Our Ref: TR010064

Date: 28 January 2025

Application by National Highways for an Order Granting Development Consent for the M60/M62/M66 Simister Island Interchange Project

The Examining Authority (ExA) writes to the parties listed above, under rule 17 of the Infrastructure Planning (Examination Procedure) Rules 2010, following deadline (D) 5 on Friday 10 January 2025. Having reviewed the documents submitted at this deadline the ExA requests the following further information and clarifications.

FIGURE 2.3

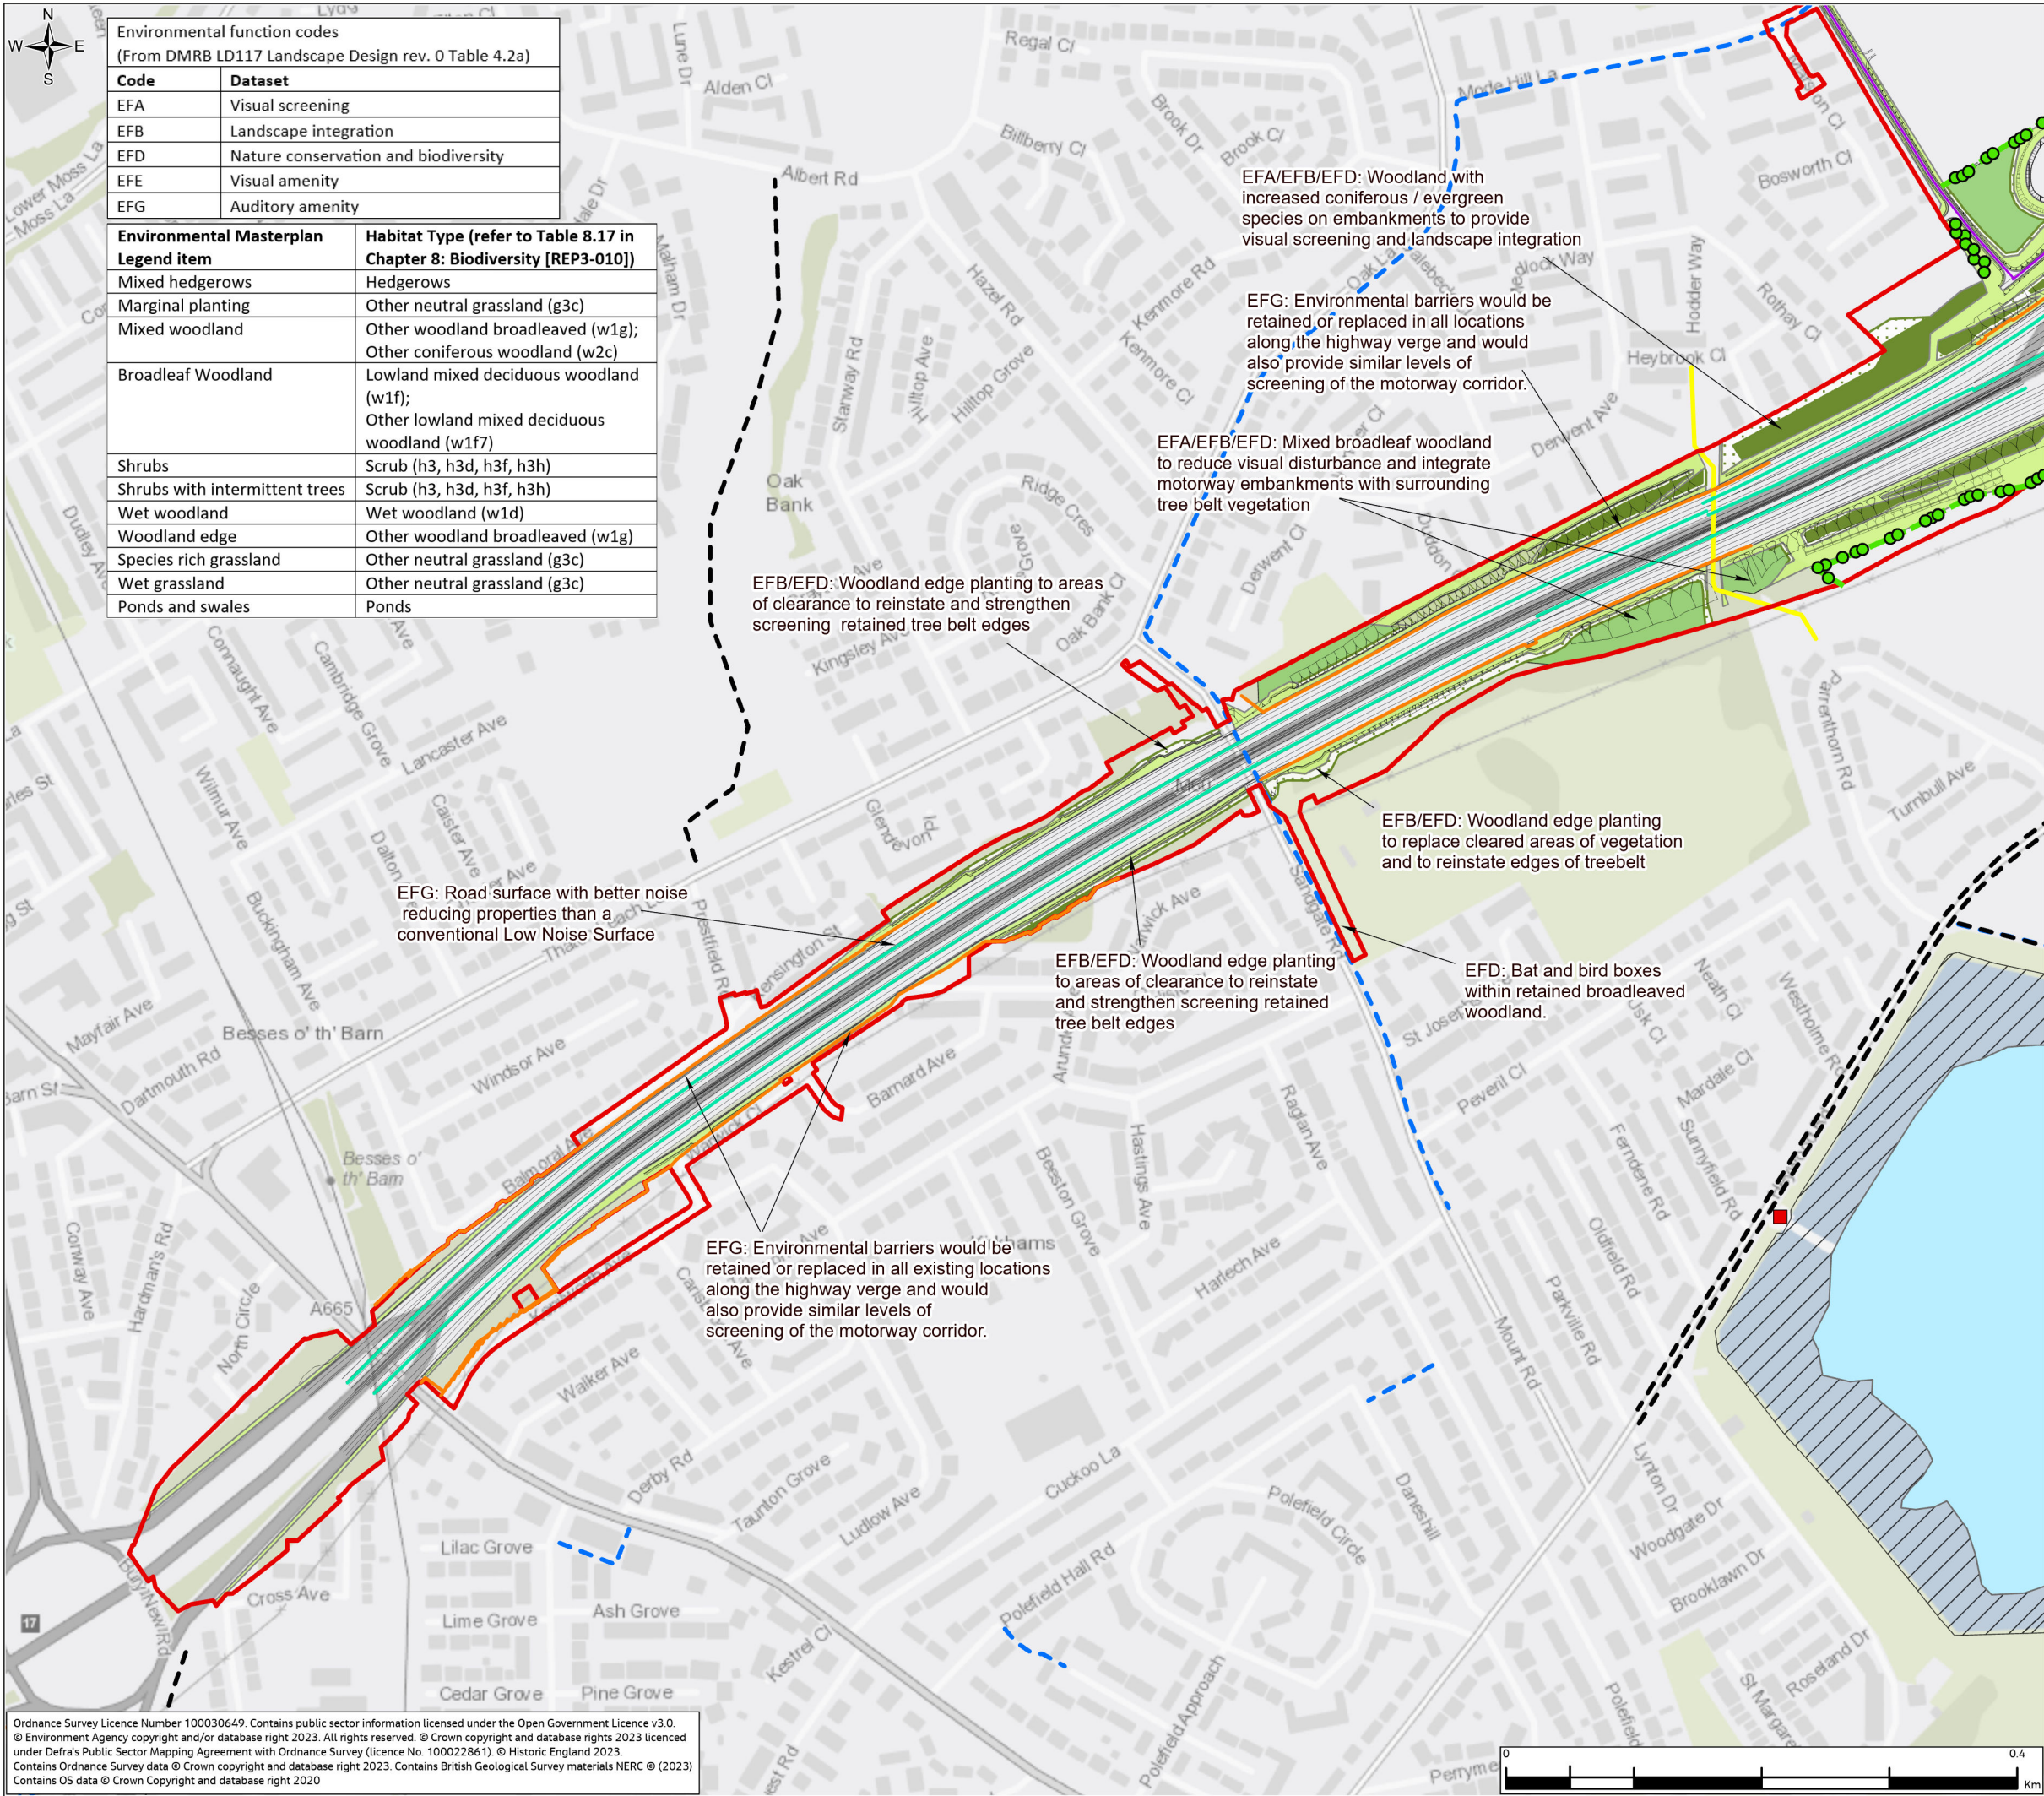
- Confirm the environmental function code for the broadleaf woodland proposed in land plot 2/16b on [REP5-017].
- Notwithstanding any tree and shrub planting proposed to the embankments of the proposed northern loop and Pike Fold Bridge, explain how the proposed areas of broadleaf woodland, areas of wet woodland and individual deciduous trees [REP5-017] across land plots 2/16b and 2/16d contribute to reducing the significant effects identified in [REP4-020] at the visual receptors represented by viewpoints 3, 5 and 7.

- Figure ExQ2 BIO2.2 [REP5-033] identifies an area within plots 2/16b and 2/16d as 'habitats to be enhanced'. However, Figure 2.3 [REP5-017] annotates these areas for nature conservation and biodiversity purposes to 'retain and protect areas of existing grass'. Explain how these areas can be considered an enhancement if they are proposed to be retained and protected. In addition, explain further why an existing area to be retained and protected requires compulsory acquisition.
